Planning Application No: 3/2025/0733

Proposal: Proposed side extension with front and rear dormer roof extensions.

Location: 41 St Marys Drive Langho BB6 8DL

PROPOSED SITE PLAN
(SCALE 1:500)

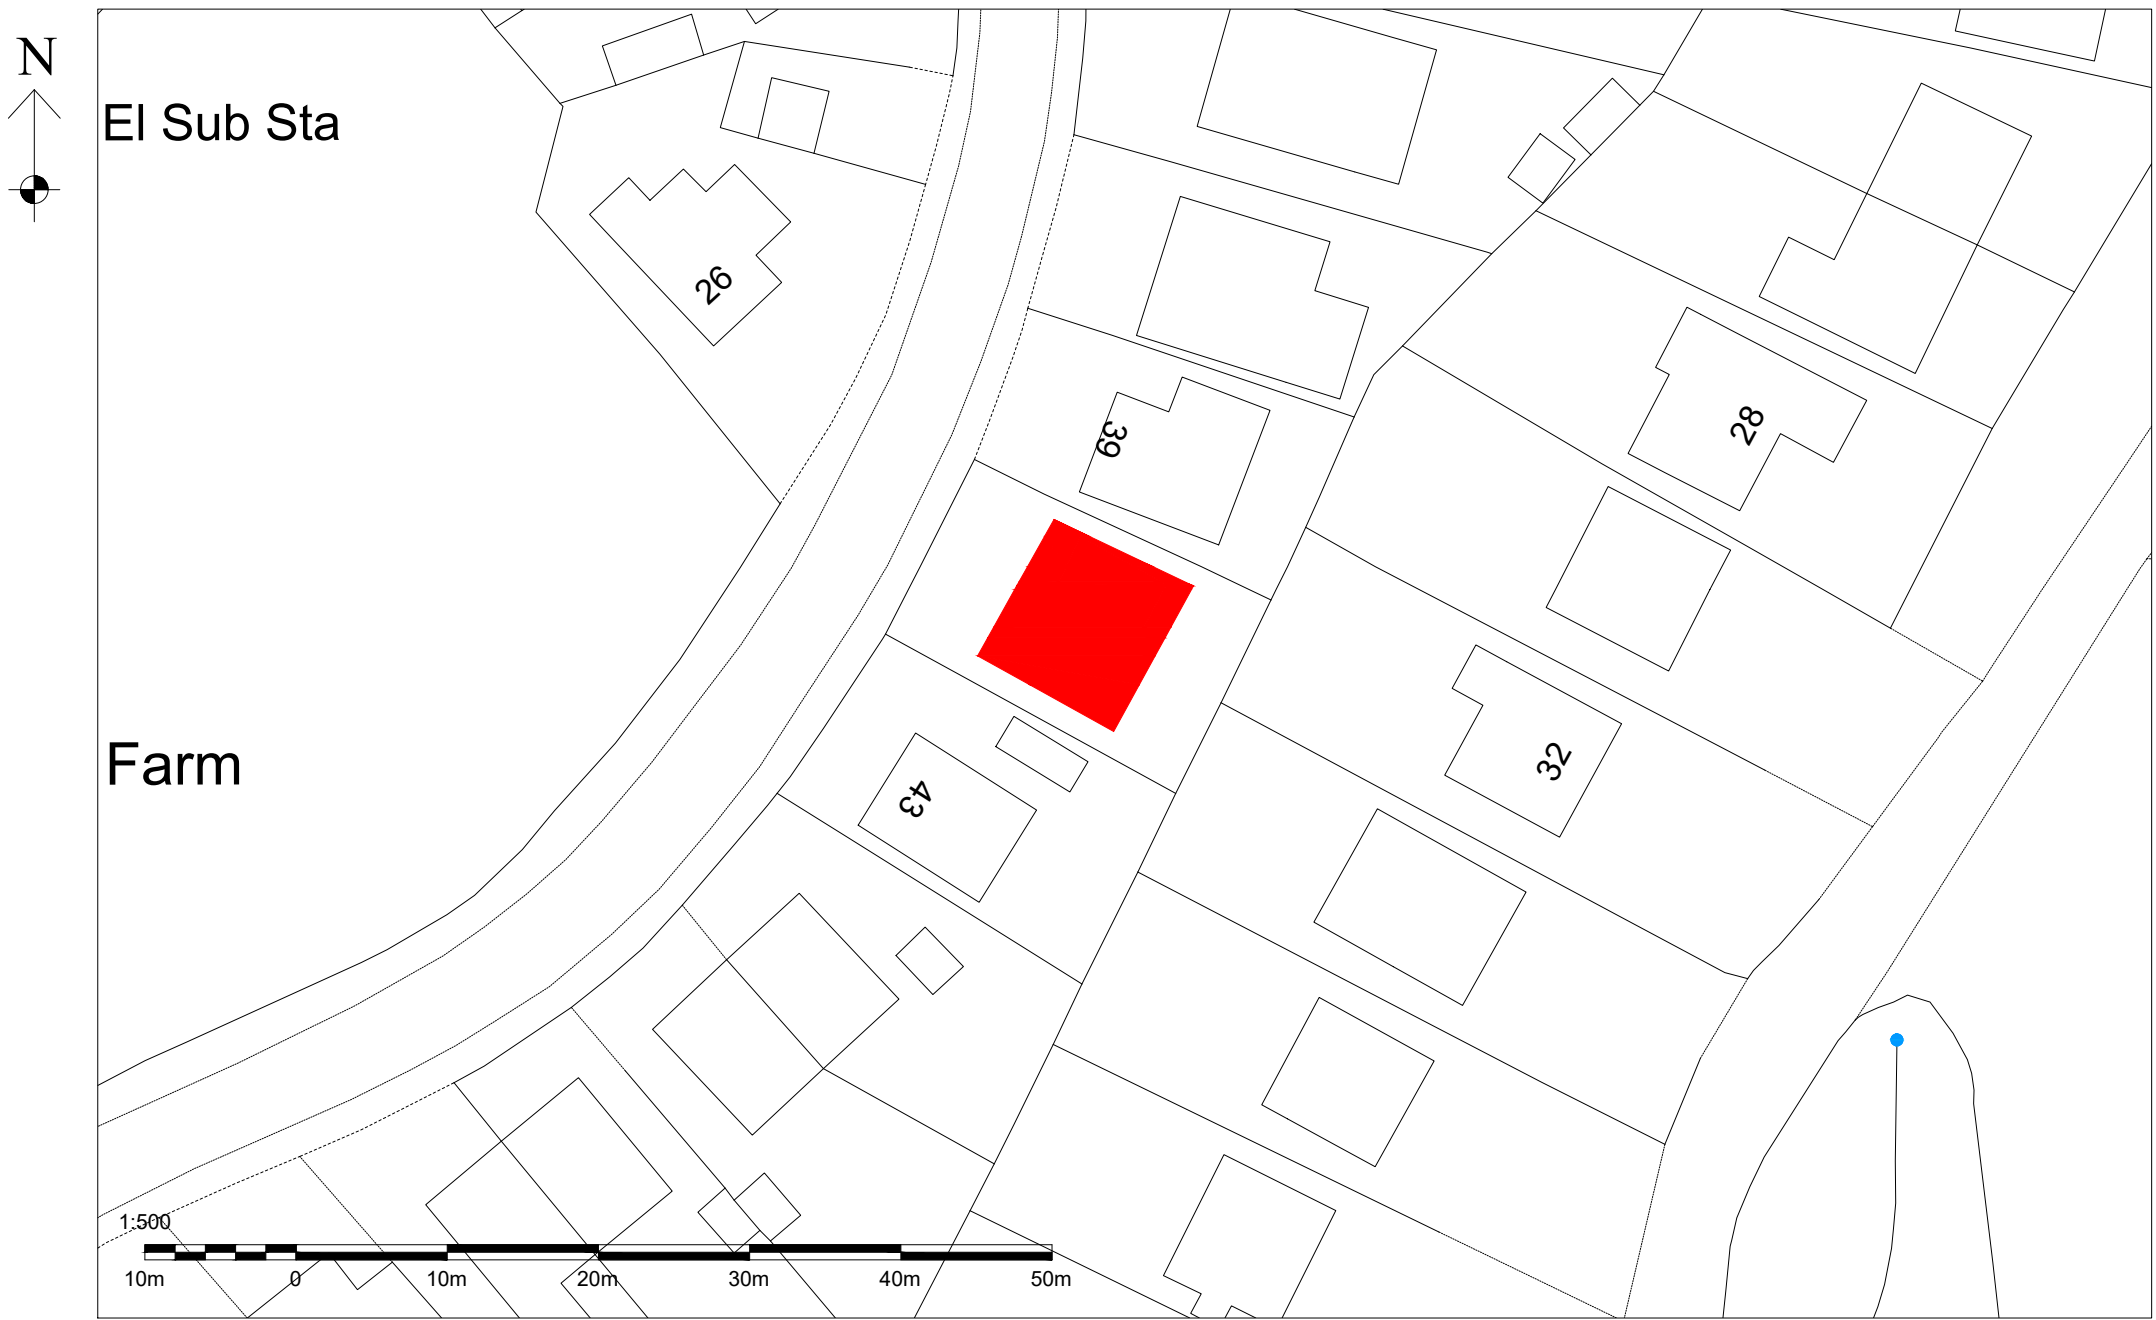
There is a loss of a garage with this proposal and an increase in the number of bedrooms from 2 to 4, therefore, an increase in parking standards requirements. 3 parking spaces are required for this size of proposal. There is no objection, subject to 3 parking spaces being available on the drive.
